**RE: SHOALHAVEN STARCHES EXPANSION PROJECT
MODIFICATION NO. 19 (MOD 19)
RESPONSE TO REQUEST FOR ADDITIONAL INFORMATION**

I refer to the Department's email dated 30th October 2020 which detailed issues arising from an assessment of the application by DPIE's Hazards Team. This submission has been prepared to respond to the matters raised in this email. The responses are a combination of comments supplied by Pinnacle Risk Management ("PRM") (who prepared the original PHA for this Mod and it is the PHA that is referenced through this submission) as well as staff from Shoalhaven Starches. The submission utilises the same numerical approach adopted by the Department's email.

**Figure 2. Proposed Ethanol Distillery Modification, Cooling Towers and Storage Silos – Shoalhaven Starches, Bomaderry, NSW**

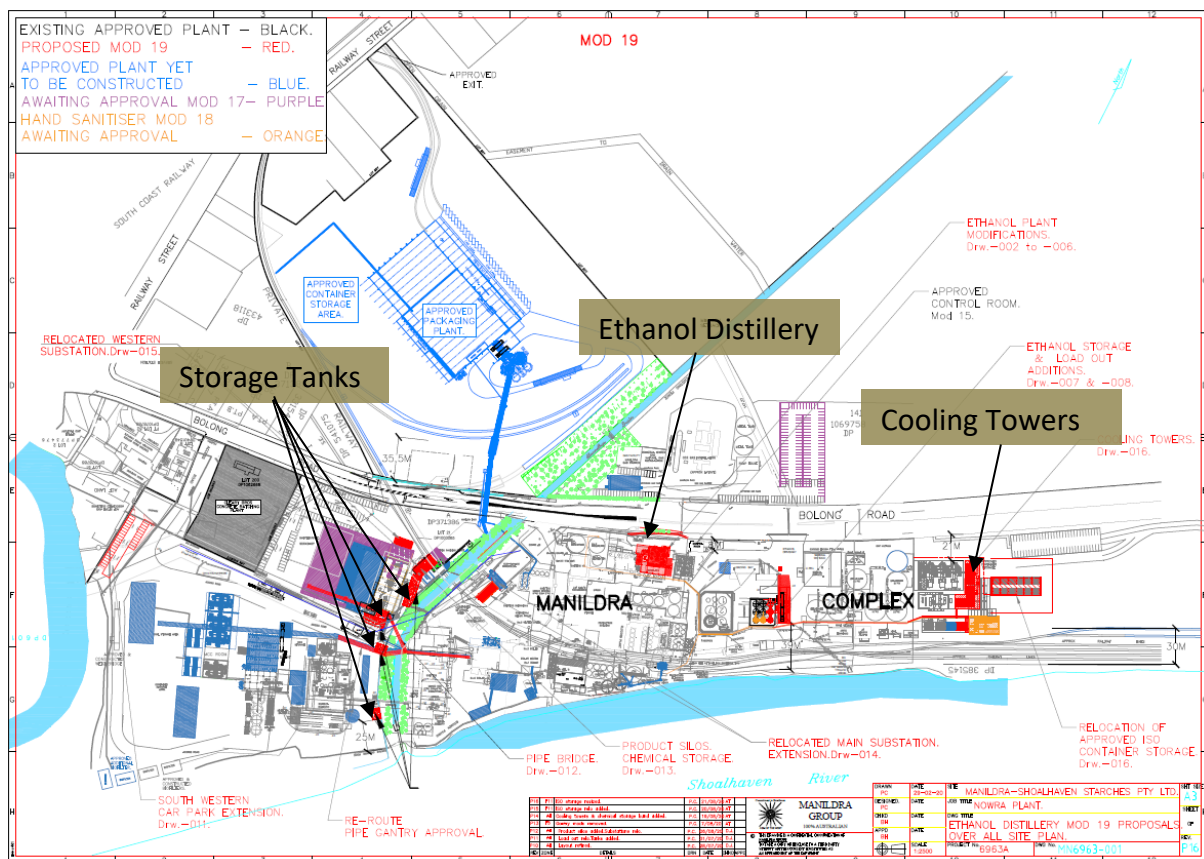
3. *It is difficult to identify the new location for the Distillery control centre in Figure 2 or Figure 6, please indicate where the new location in a figure and verify whether any fire or explosion impact may affect the control room in the new location.*

The control room is labelled “Approved Control Room Mod 15” on Figure 2 in the PHA and is located adjacent to Bolong Road for ease of escape in an emergency. It is double-brick construction, re fire resistant. At this location, according to PRM, the radiant heat may be up to 12.6 kW/m² from a large pool fire at the Beverage Grade Ethanol Plant Number 1. The explosion risk is discussed on Point 5 below.
